1st July 2024

RE: OBJECTION AGAINST ERECTION OF DETACHED DWELLING AT LAND ADJ. 4 DOWNING STREET, LINTHWAITE, HUDDERSFIELD, HD7 5PU

LPA REF: 2024/90932

Front Elevation SE
1 : 100

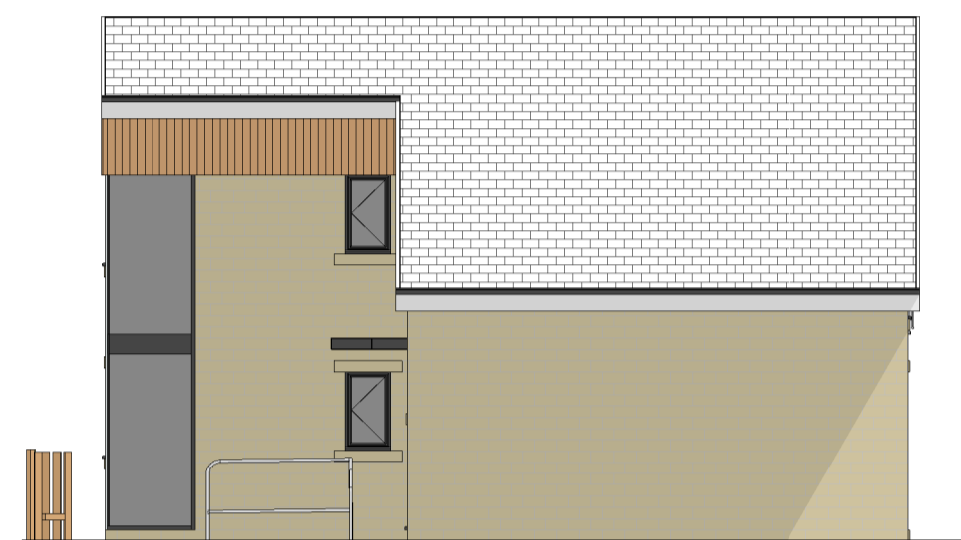
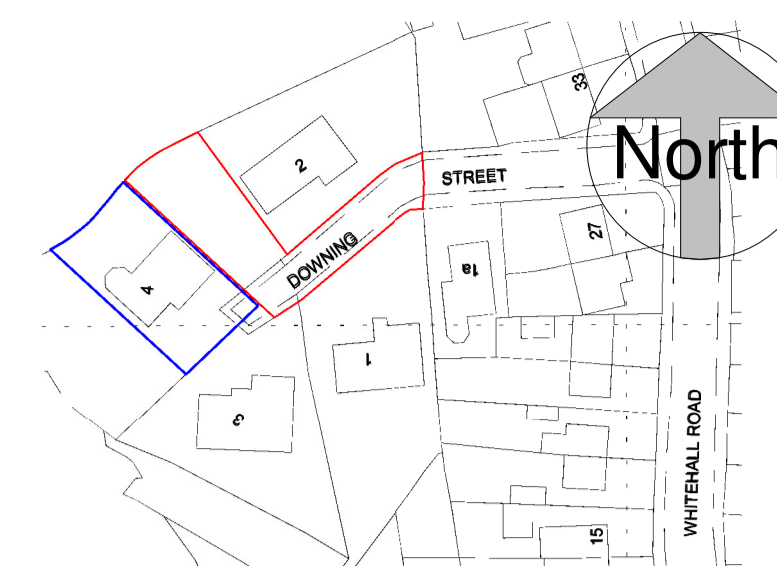
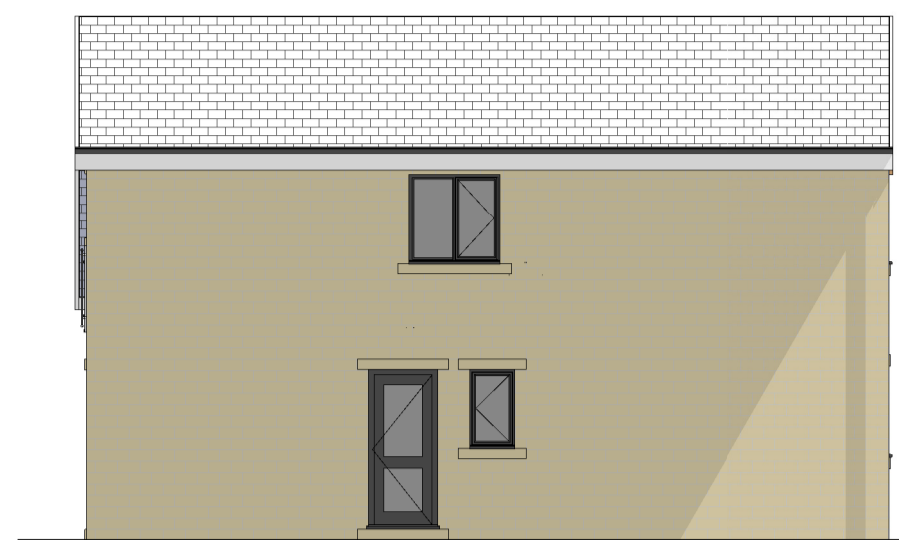
The proposed dwelling comprises of a two-storey property constructed of coursed stone with timber boarding. The front elevation includes a protruding gable and extensive glazing, and the roof of the dwelling currently shows a 'cat slide' style roof.

Although the coursed stone and protruding front gable are design features associated with the neighbouring properties, the timber boarding, double height glazing on the front elevation, and the 'cat slide' roof are considered to be out of context and not in keeping with the existing character of the street and neighbouring properties. Given the siting of the proposed dwelling between No's 2 and 4, and its close proximity to these neighbouring properties, the proposed dwelling would result in an incoherent design that doesn't relate well to the adjacent dwellings or the street scene as a whole.

Ground Floor Plan
1 : 100

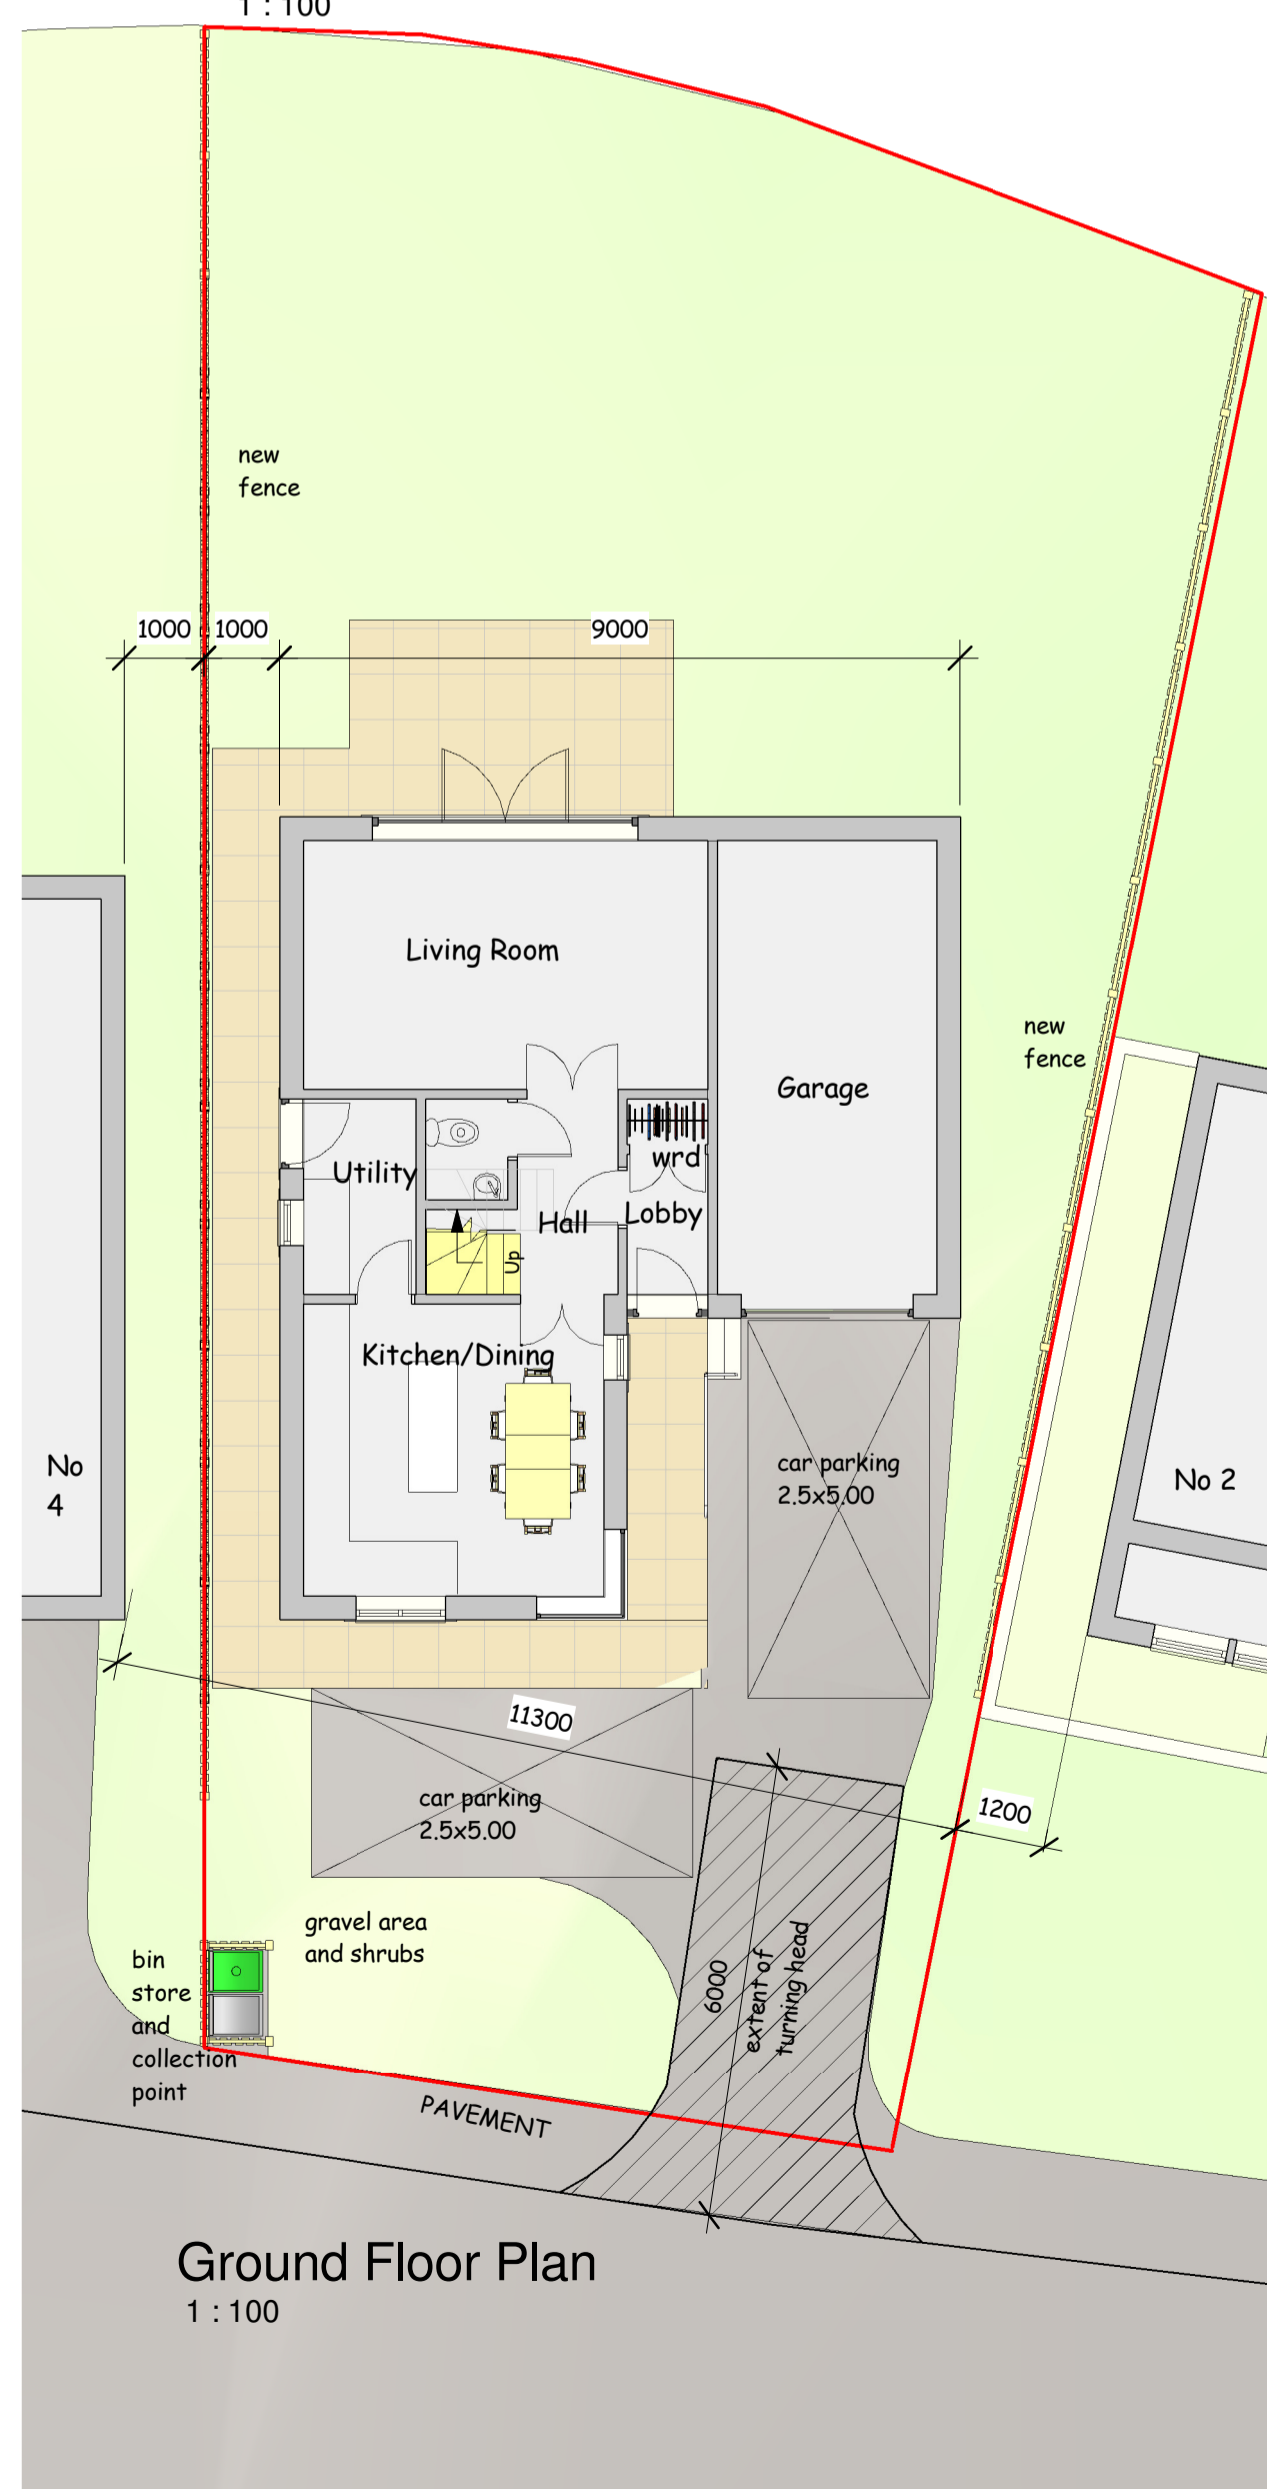
The proposed Ground Floor Plan shows two off-street parking spaces at the front of the proposed dwelling. These are in addition to the turning head. The proposals would therefore result in the front of the dwelling being almost entirely dominated by hardstanding. Due to the cramped nature of the application site, however, it is not considered that 'creative design solutions' could accommodate the parking at either the side or rear of the proposed dwelling as an alternative. The proposals would therefore have a detrimental impact on visual amenity in this regard and do not comply with Principle 12 in the SPD.

Block Plan
1 : 500

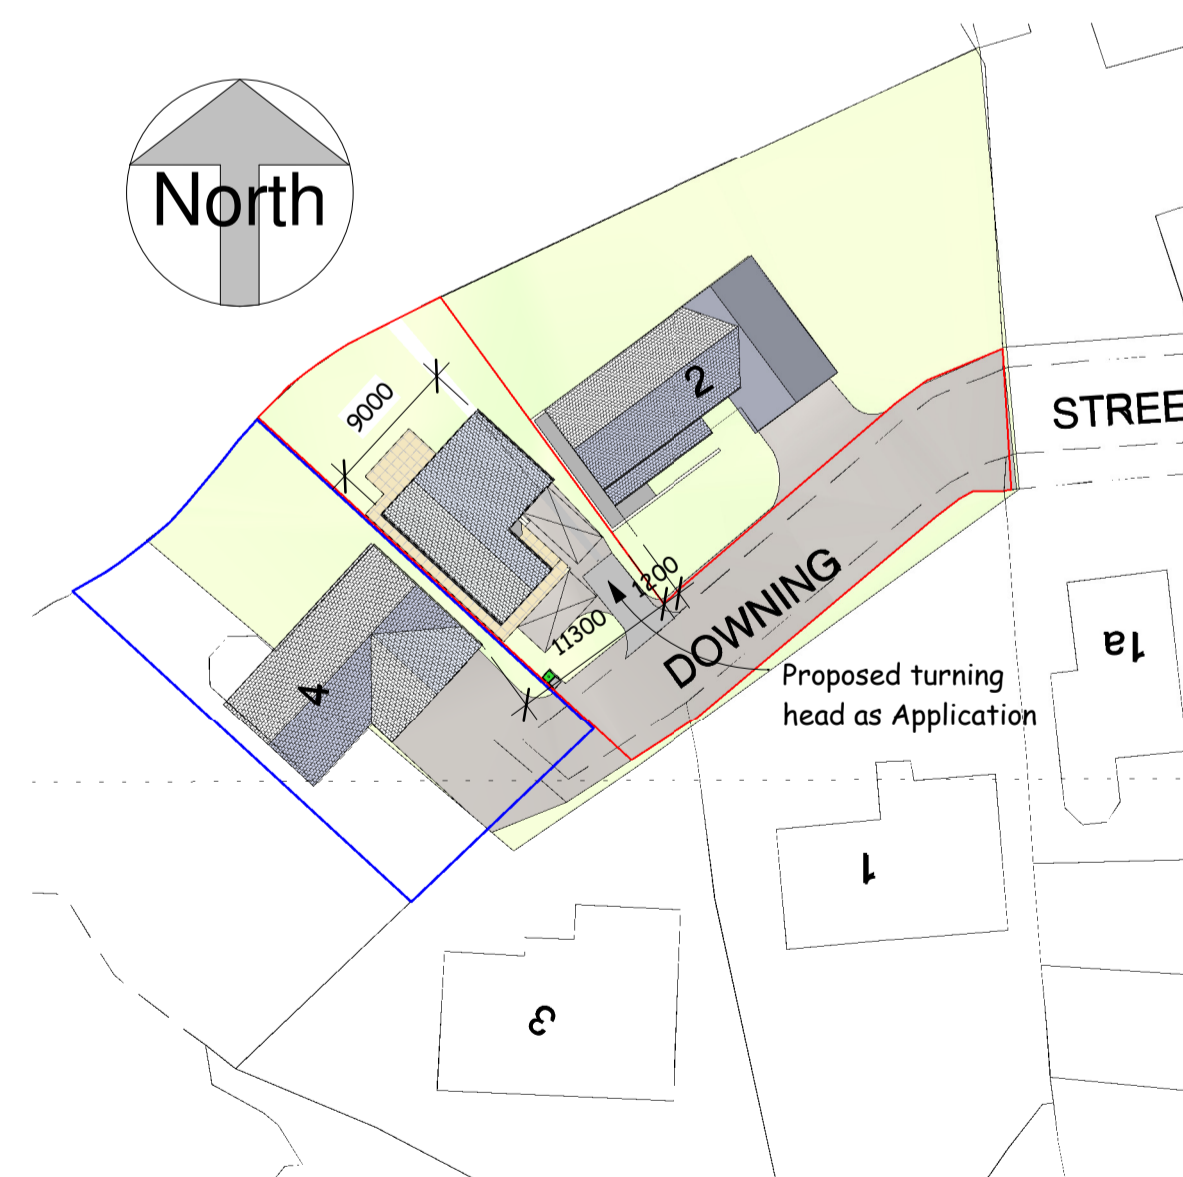
Although the turning head has been included on the plans submitted as part of this application, our client is concerned that the proposed development would nevertheless have a detrimental impact on his extant planning permission, in particular his ability to comply with condition 7 above.

The original intention for the turning head in our client's application was that it would be located on land that is away from the neighbouring dwellings and away from residents private off-street parking. The proposed development by contrast now incorporates the turning head within the application site for the proposed dwelling. Vehicular access over the turning head would therefore be required for future occupants to enter/exit the plot. The proposals would therefore conflict with our client's development quite significantly.

As a result of the applicant trying to squeeze a new dwelling onto a small plot, the recommended separation distance of 2 metres to the shared boundaries has not been complied with. The proposed plans show that only a gap of 1 metre is achieved between No. 4 and the new dwelling, and only a gap of approximately 1.2 metres can be achieved between No. 2 and the new dwelling. Due to the close proximity of the proposed dwelling to the neighbouring dwellings, the proposals would have an overbearing and overshadowing impact, particularly on No. 2 as this property is located at a slightly lower level. The proposals would therefore cause undue harm to residential amenity and do not accord with Principle 6 in the SPD.
